**From:** Contact Centre (CRM) <contact@ribblevalley.gov.uk>  
**Sent:** 02 November 2022 15:43  
**To:** Planning  
**Subject:** Planning Application Comments - 3/2022/0861 FS-Case-462788223

**Planning Application Reference No.:** 3/2022/0861

**Address of Development:** 21A Knowsley Road  
Wilpshire  
BB1 9PX

Erection of an Outbuilding in the Front Yard	
Proposed	
21A Knowsley Road, Blackburn, BB1 9PX	
Page Size	A1
Date	02/10/2022
Client	Nasir Mehmood
KNO-02-20	
Scale	As indicated

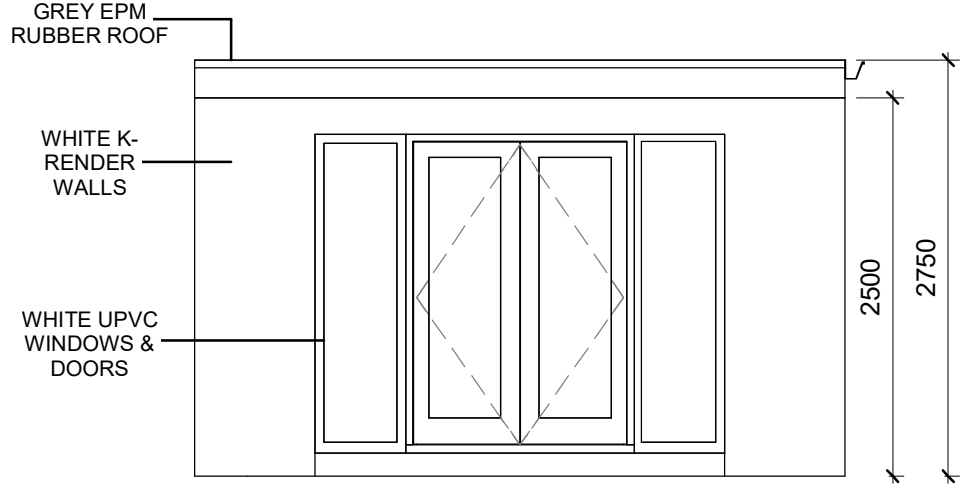
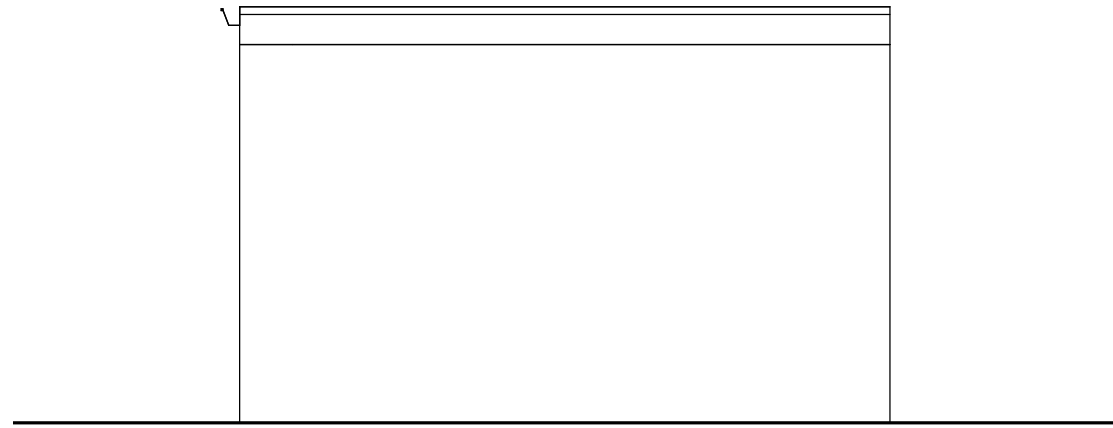
The proposed outbuilding [REDACTED] would become an eyesore if the height of the building exceeds the height of the existing wall and hedge. If the proposed building does not exceed the height of the hedge and wall, we would not have any objections.

Proposed Site / Roof Layout
1 : 200

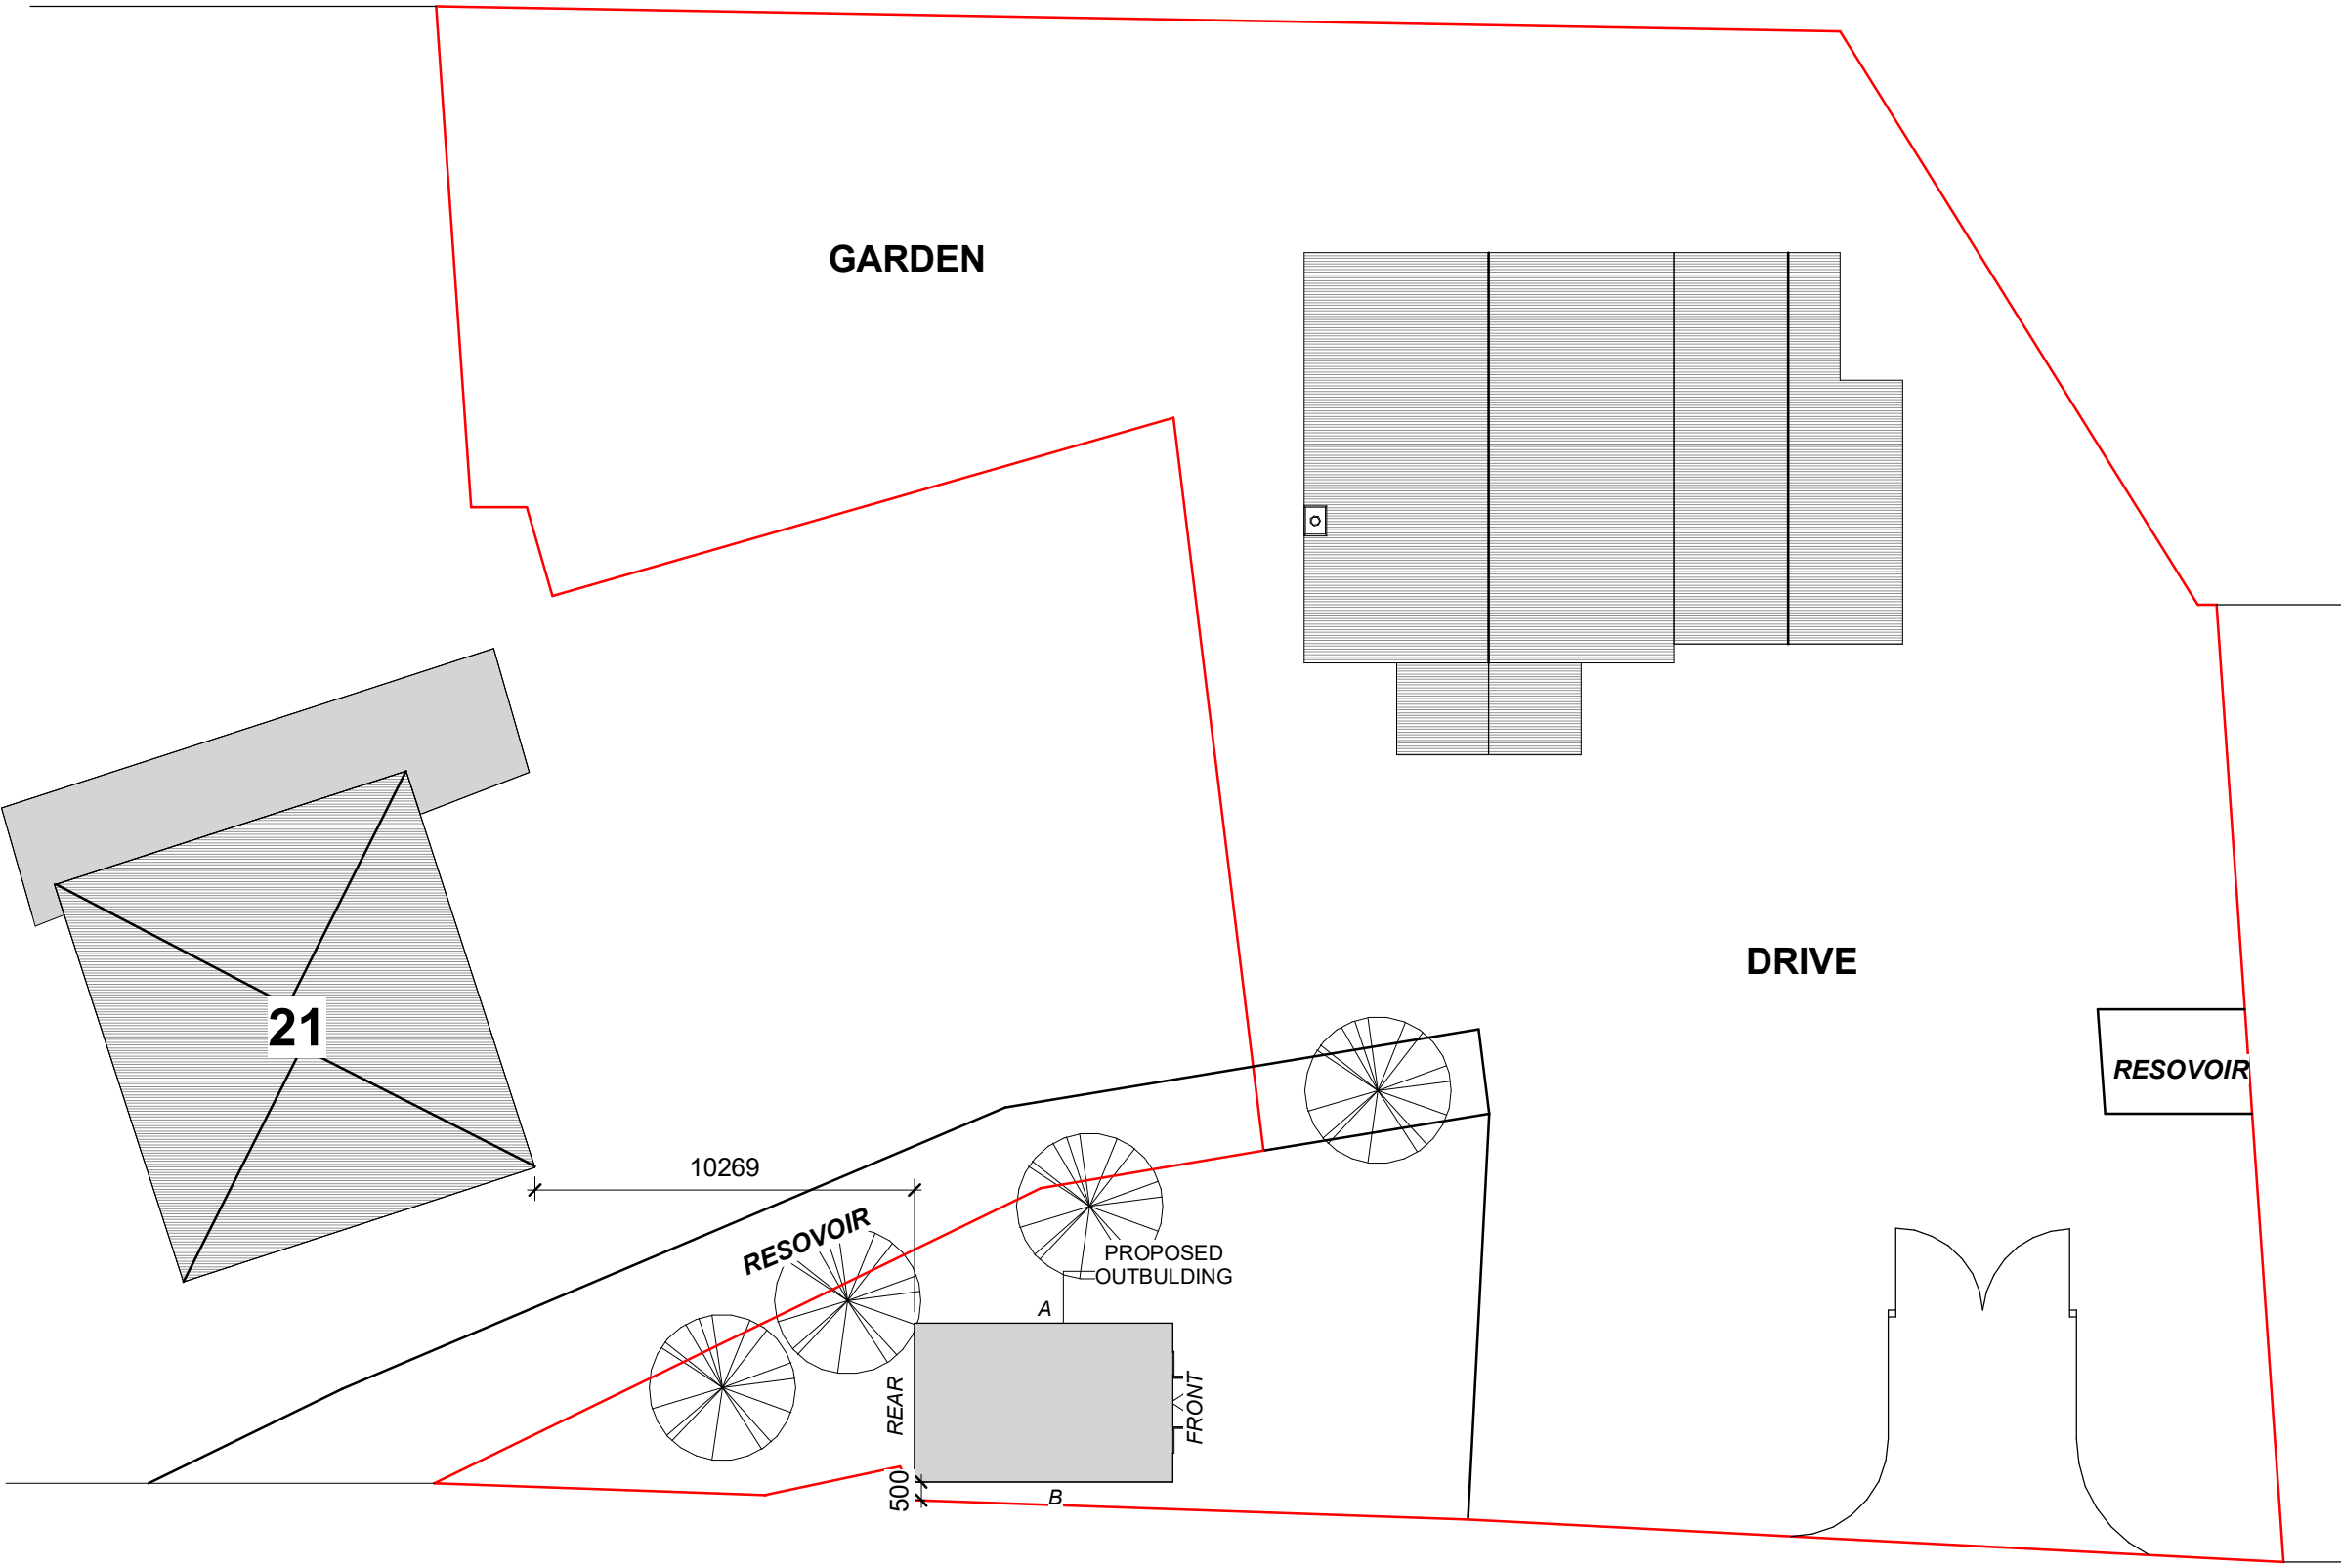
**Comments:** According to the application, it states that no work has already been started without consent. Has this been given as a concrete base for the said outbuilding was completed some 4 months ago at the beginning of July. We are aware of this as the roadside hedge of the property was damaged to enable the concrete to be poured through. Will this be replaced?

It is interesting to note that the front of the outbuilding, facing the main house, is proposed to be shielded behind bushes/shrubs.
